4 December 2024

Application: 600-660 Elizabeth Street, Redfern (Lot 1 in DP 1249145)
Application No: SSD-51274973

Please note that the comments made in this letter, are largely in relation to the findings within the Social Impact Assessment_Final document that was prepared for Bridge Housing Limited on 28 June 2024.

1PM WINTER SOLSTICE

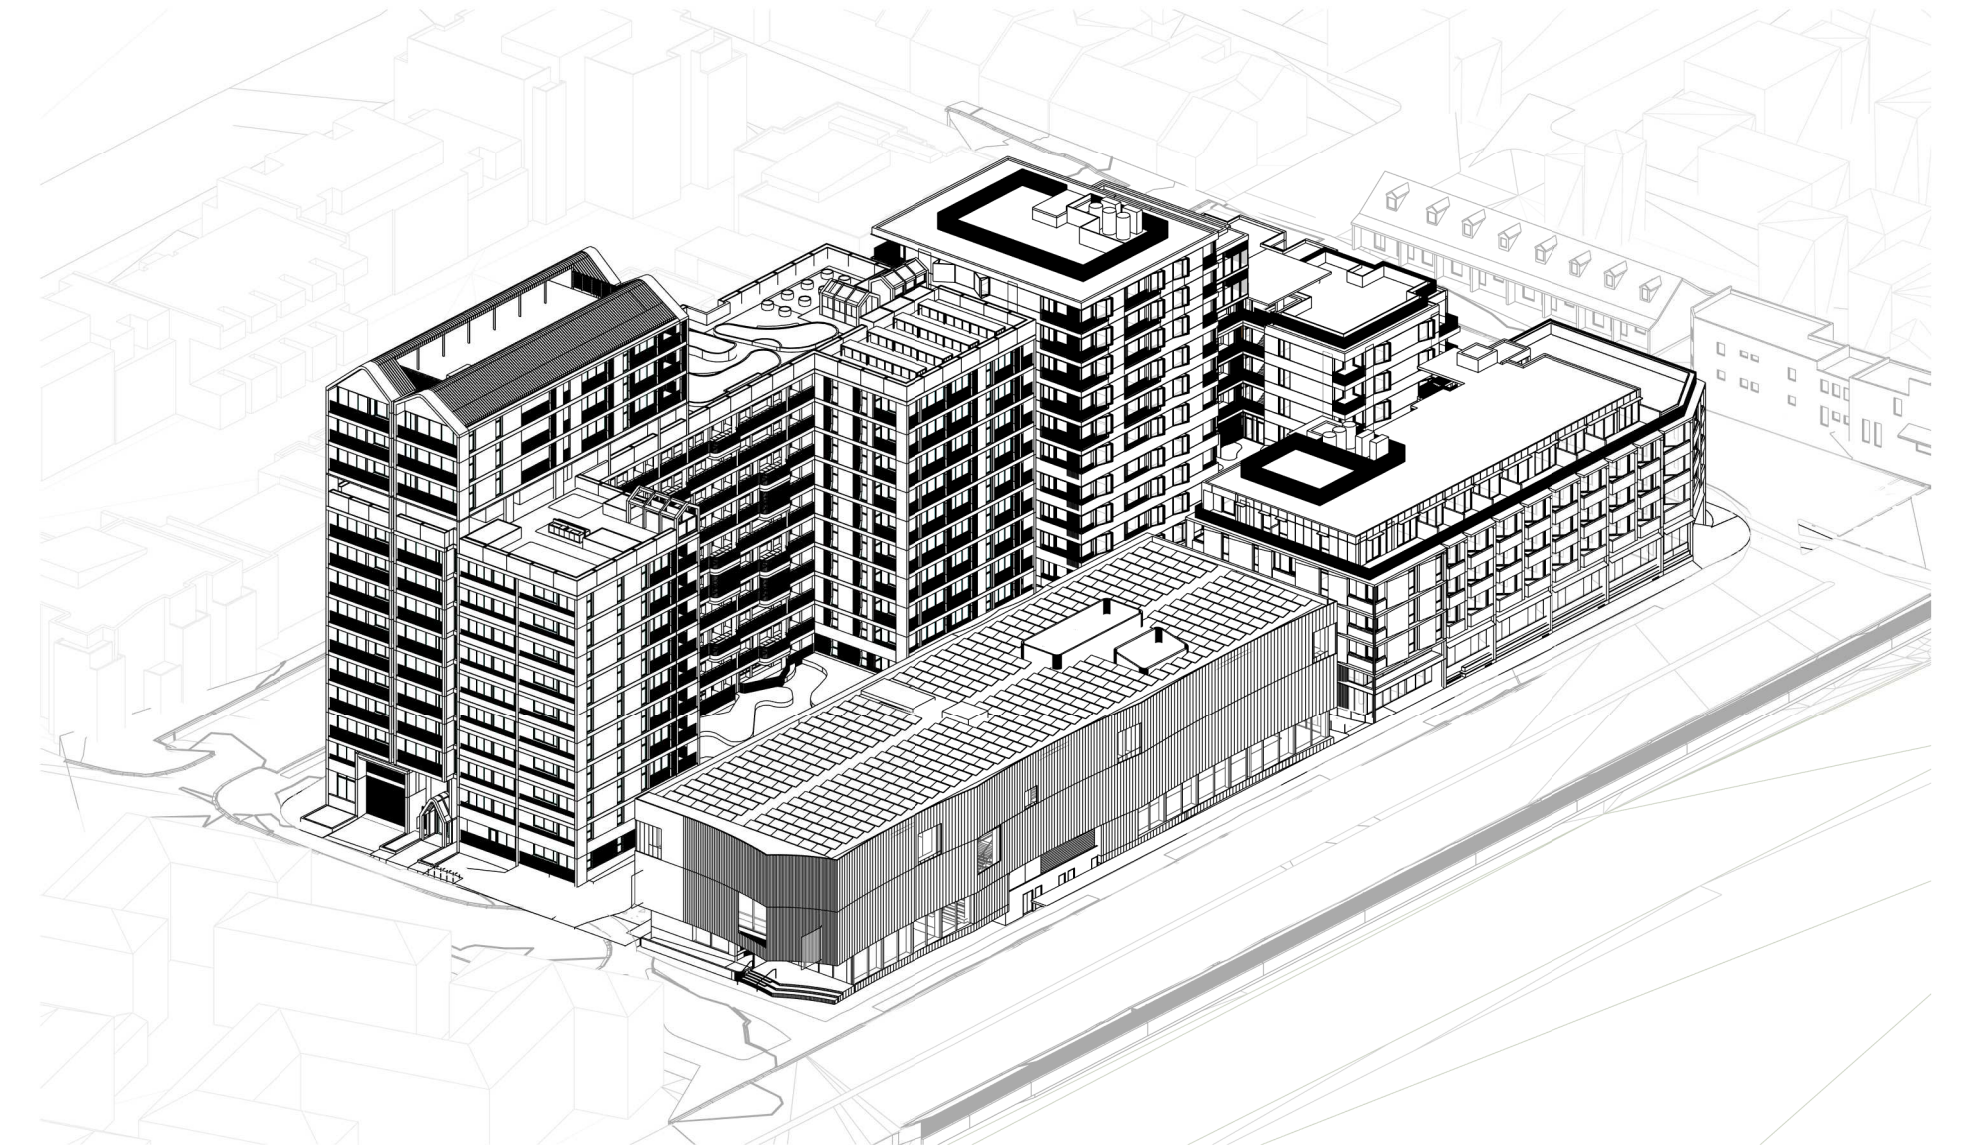
From our interpretation of the shadow diagrams, we will have shade on the front of our house for less than 2 hours a day in winter. The residents of Walker Street will have a lot more overshadowing and “bulk and size” of Redfern Place staring at them.
